Recommendation Report for Planning Permission for Works or Extension to a Dwelling

REF NO: EP/85/21/HH

LOCATION: 78 Sea Road
East Preston
BN16 1NP

PROPOSAL: Garage conversion to habitable use and installation of 1 x front dormer

Drawing Name
Floor Plans and Elevations - Proposed

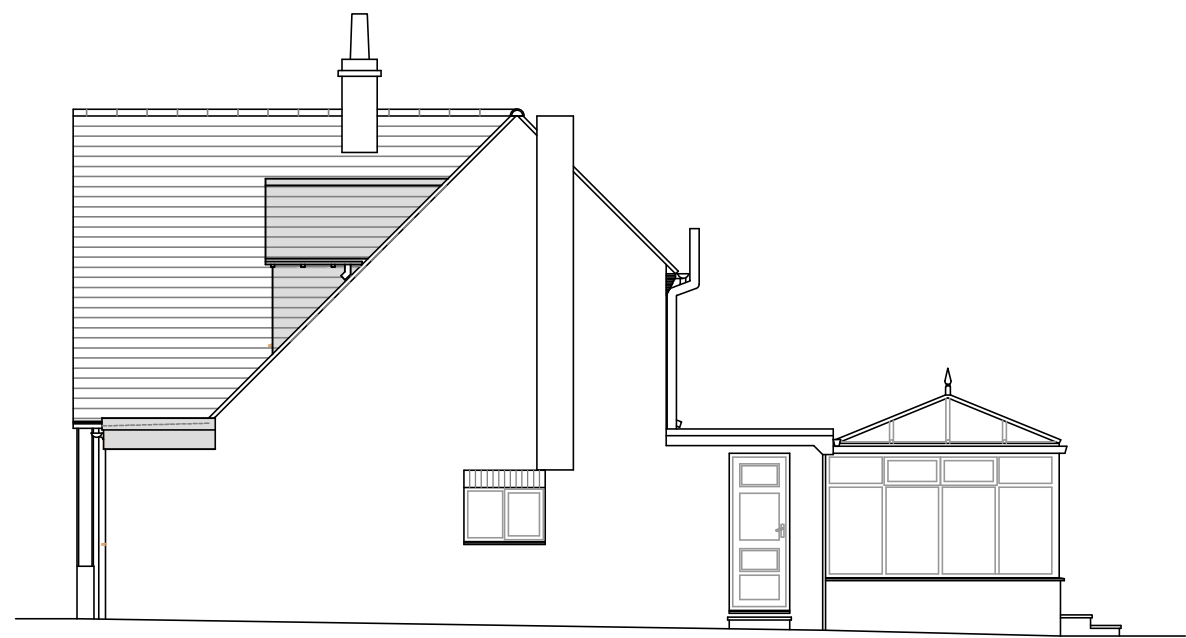
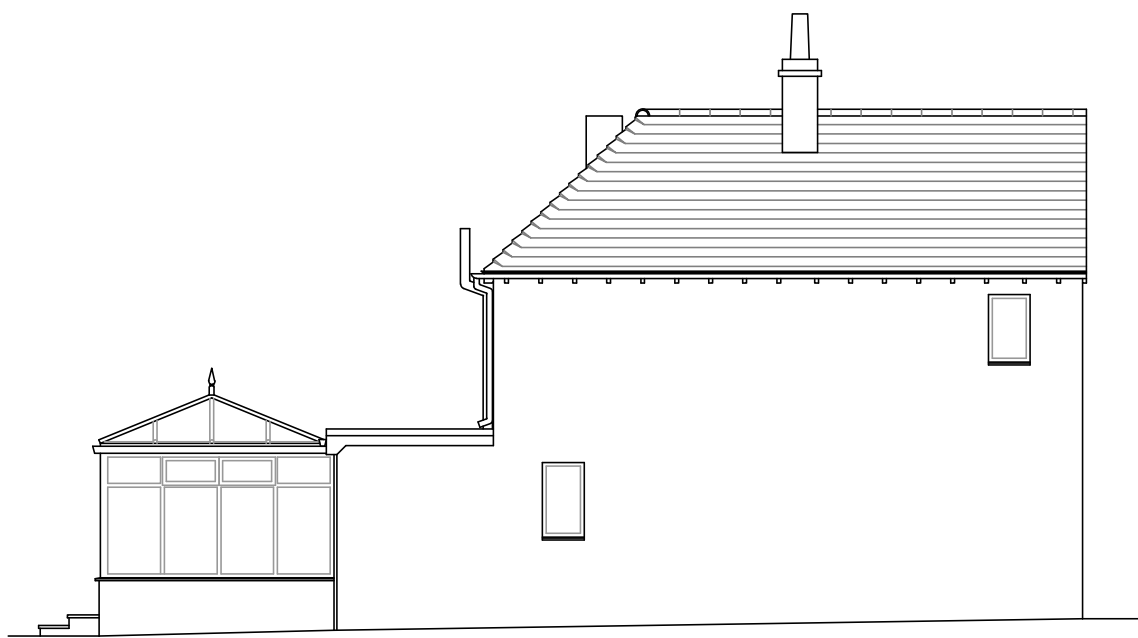
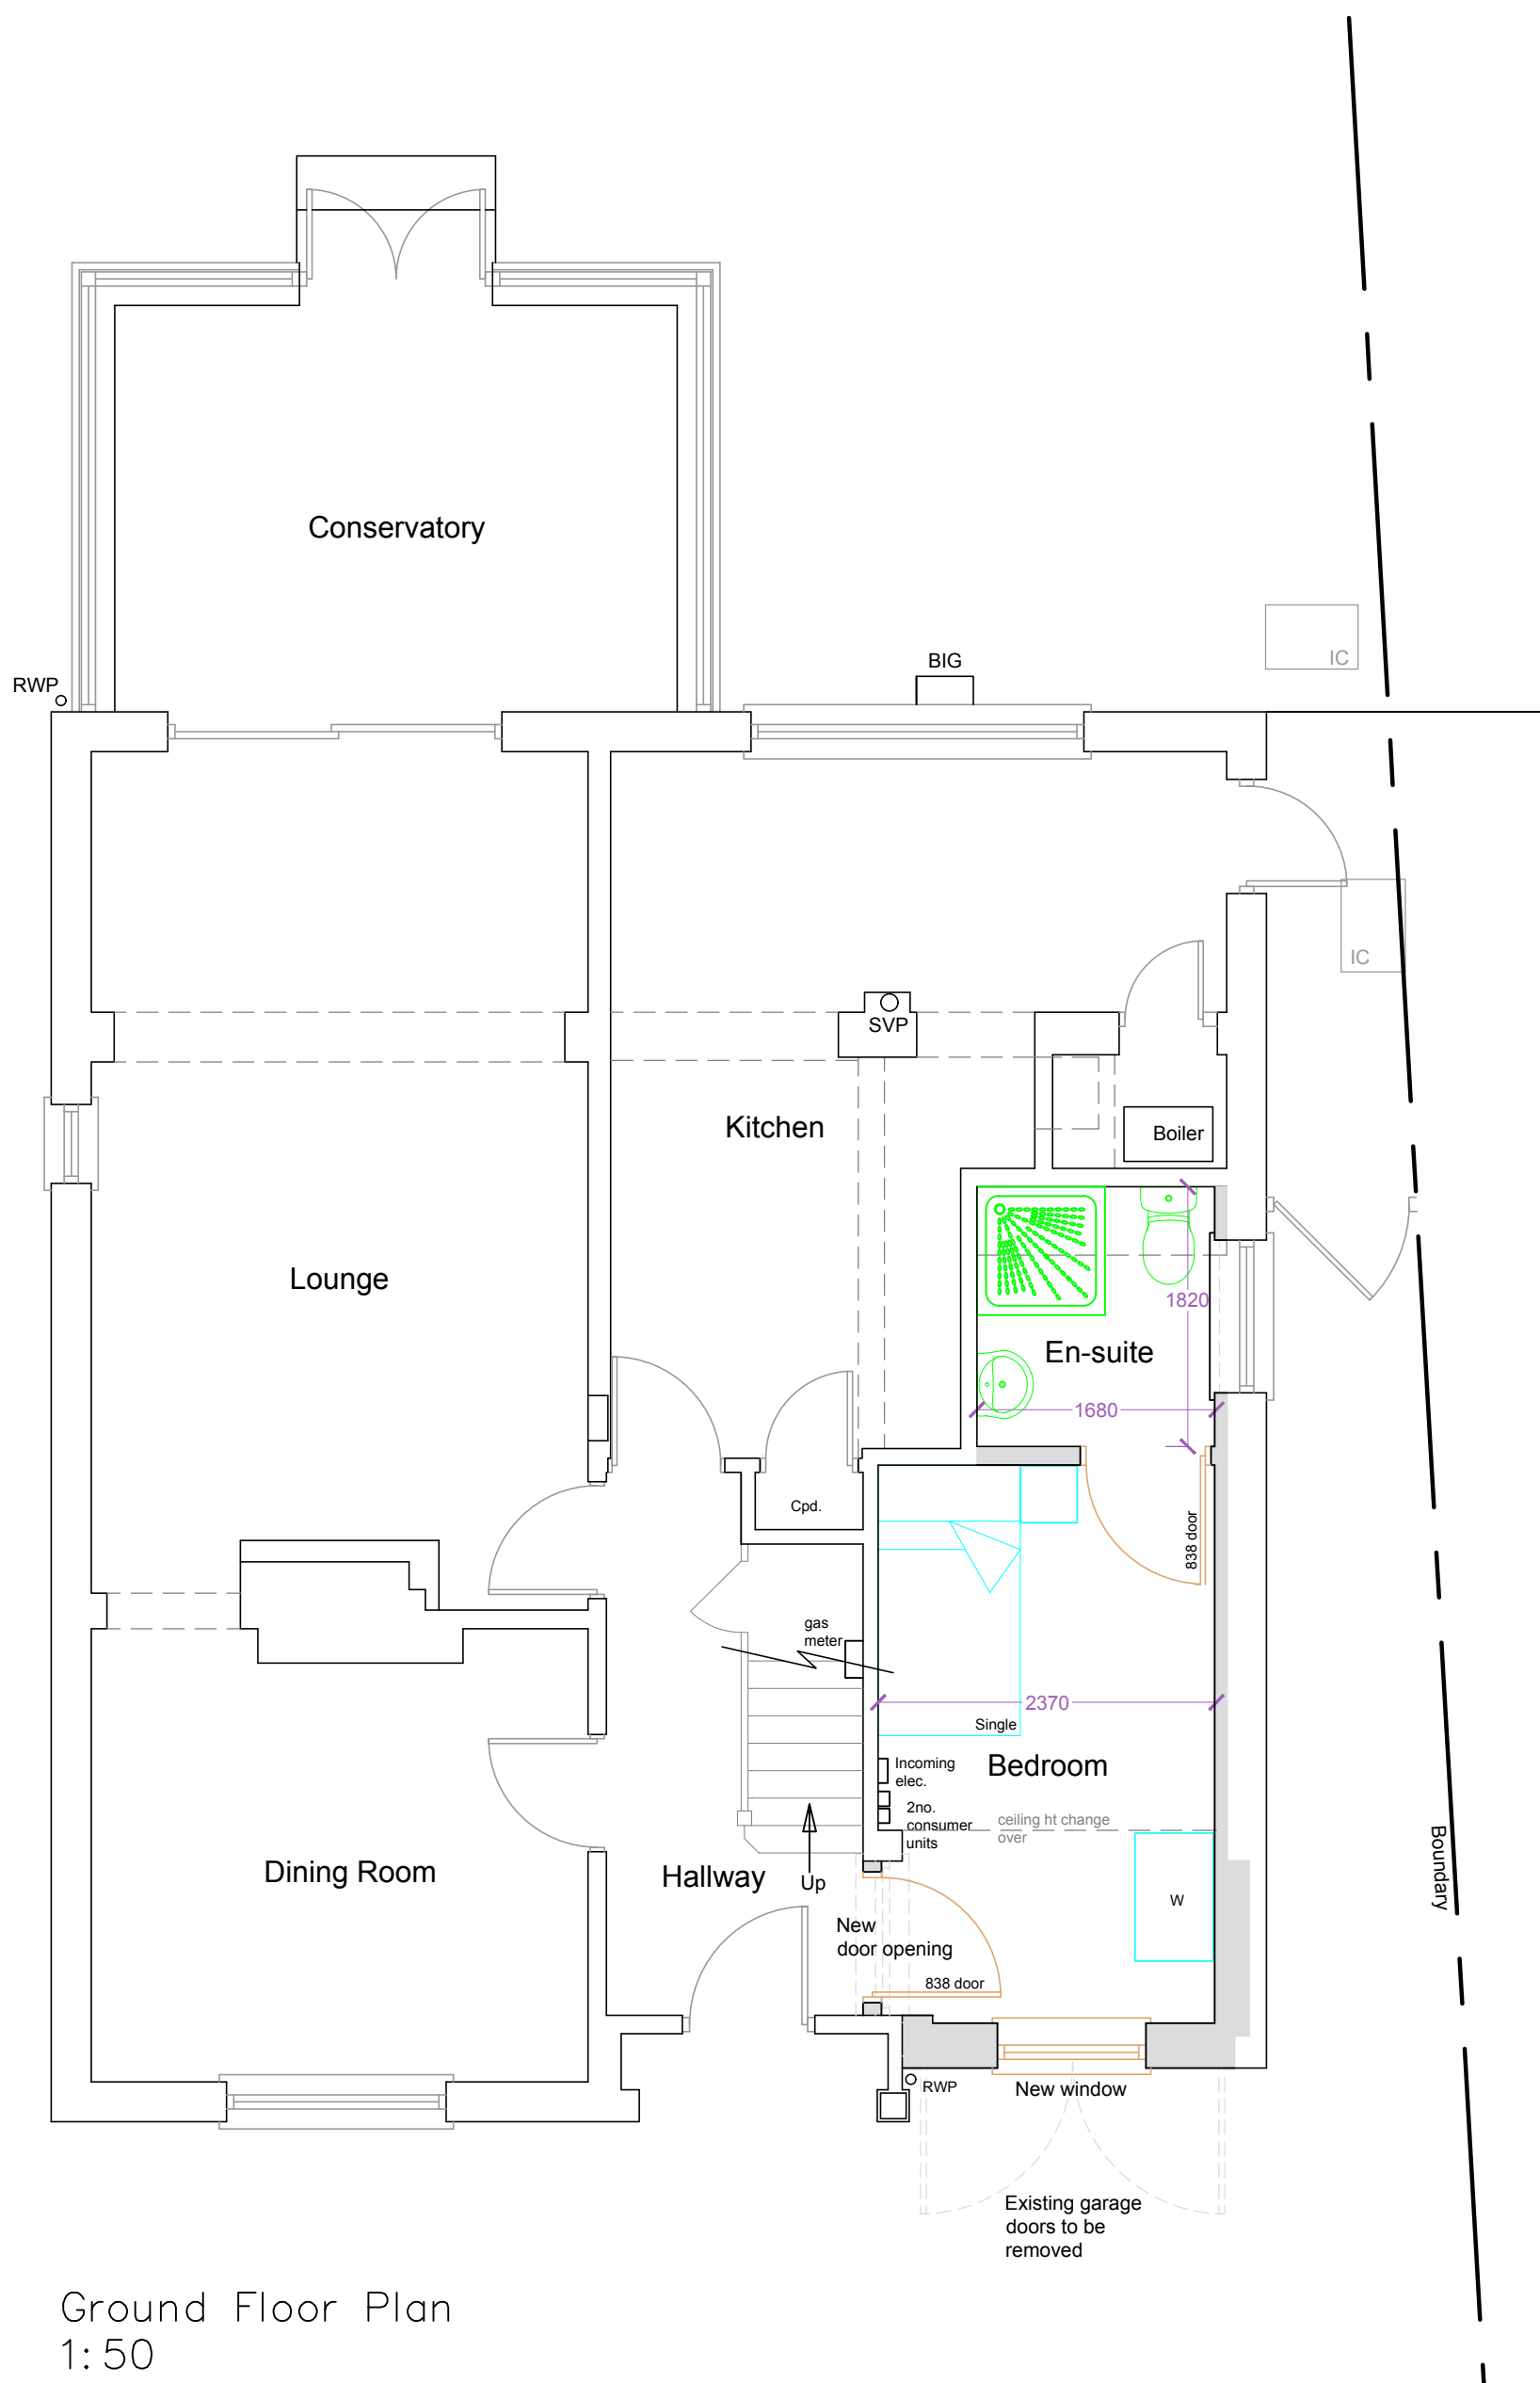
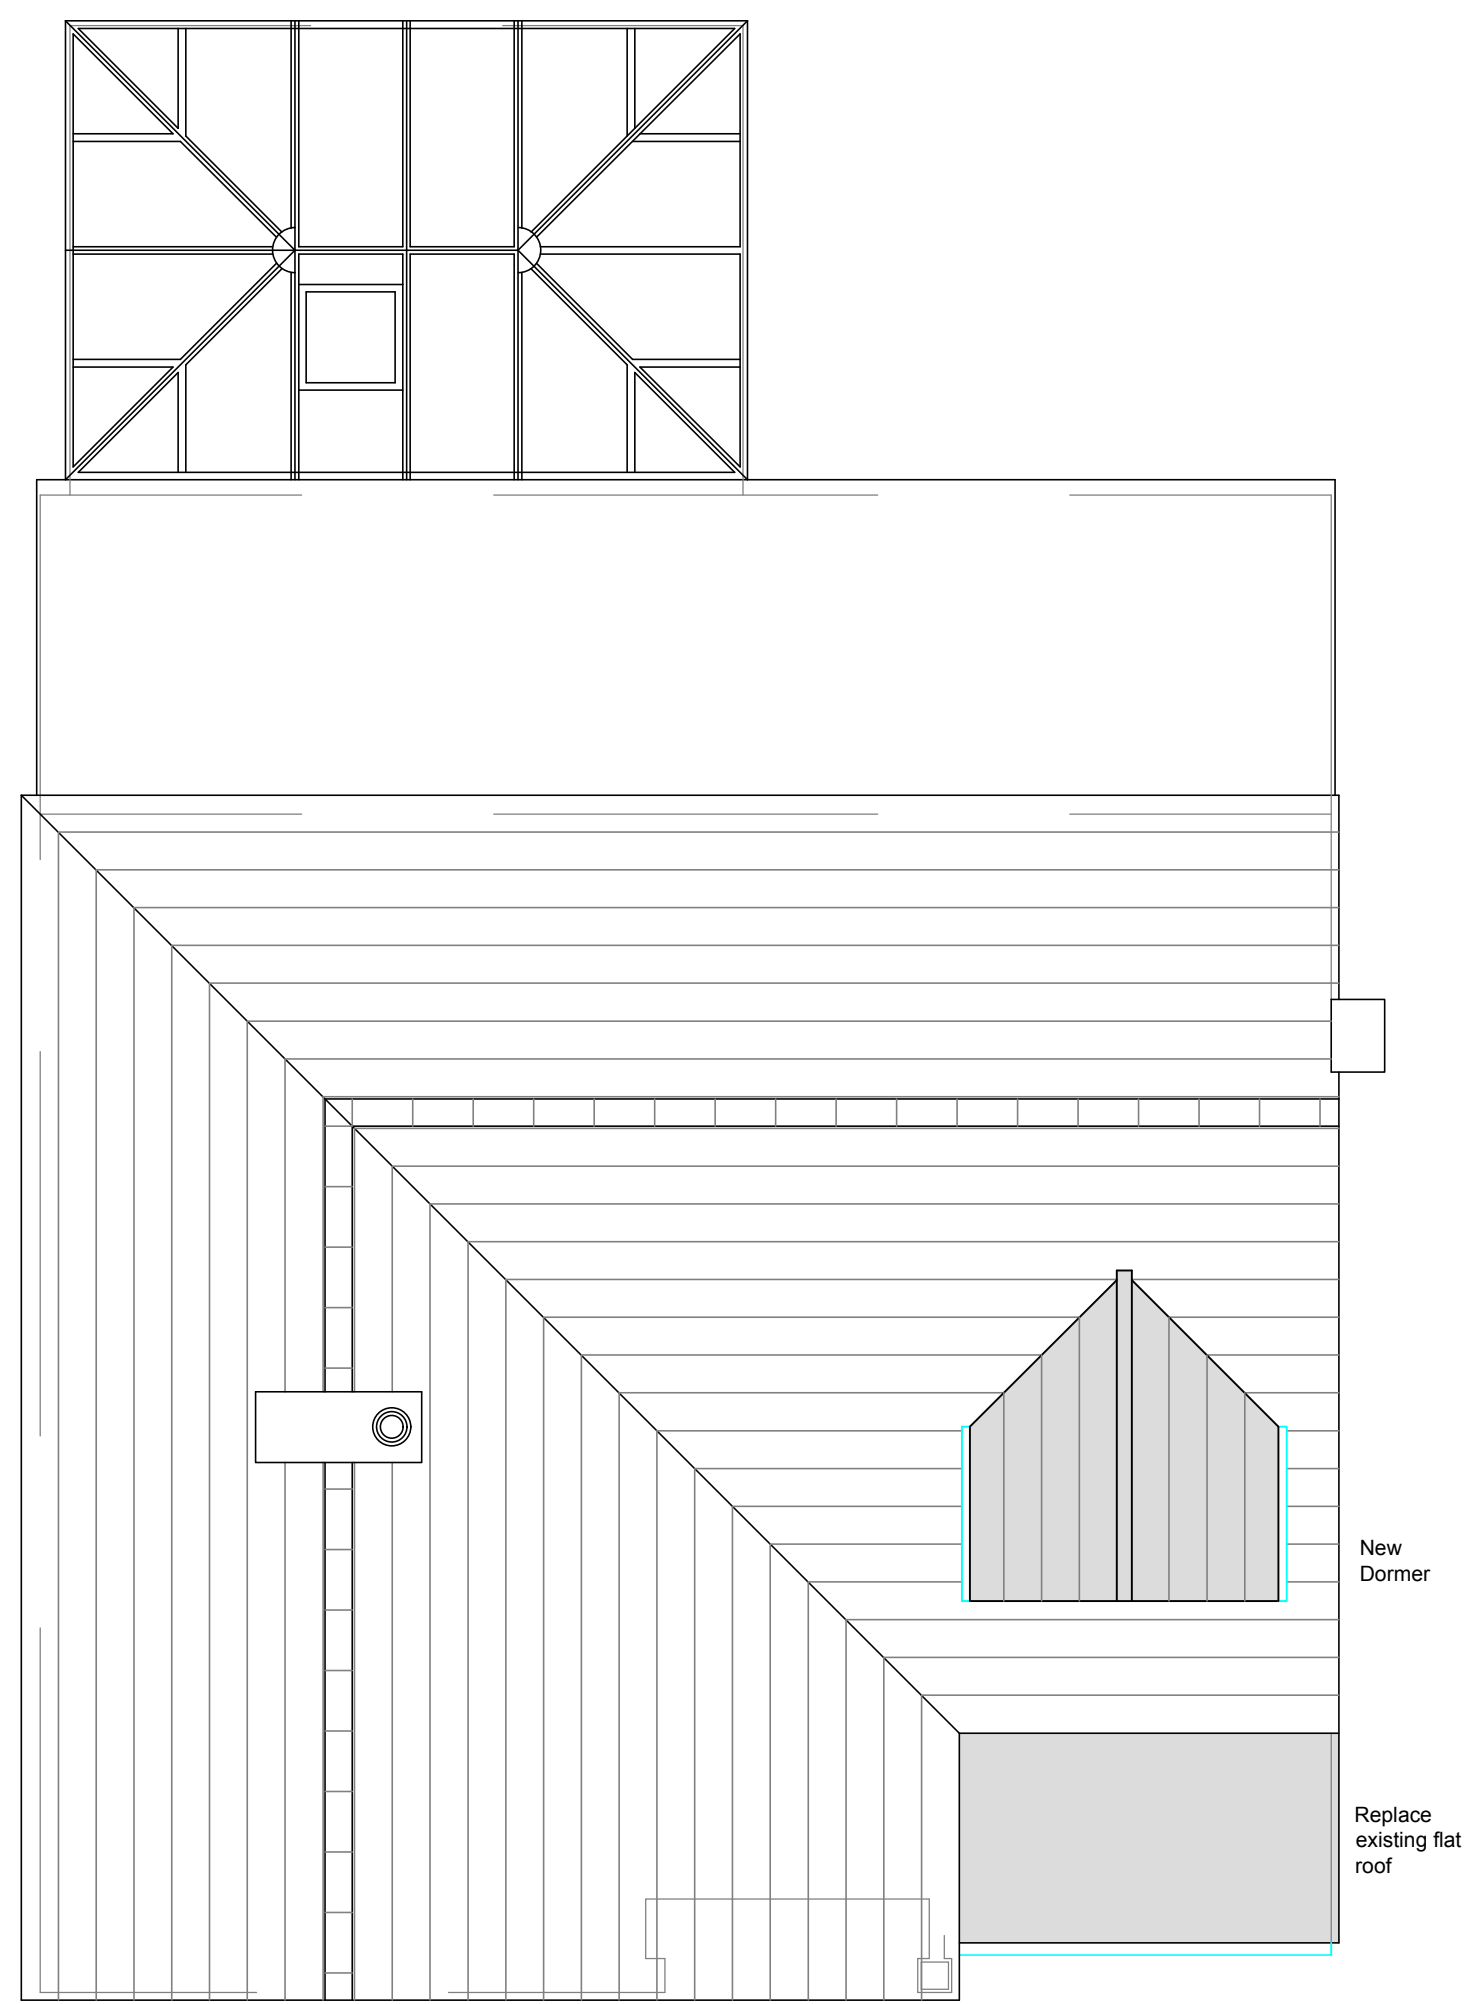
The front dormer extension will be a modest addition within the existing footprint of the dwelling whilst creating more usable floor space within Bedroom 3. This is seen as an effective form of development.

It has been designed to fit sympathetically with the host dwelling and will utilise materials which match existing finishes, and with a pitch to match the roof.

The proposed window at Ground Floor level, in place of the garage door is considered to be an appropriate scale when compared to other openings on the dwelling.

The proposed window to the dormer will achieve views over the front of the property and the public realm, no negative impacts from overlooking are anticipated.
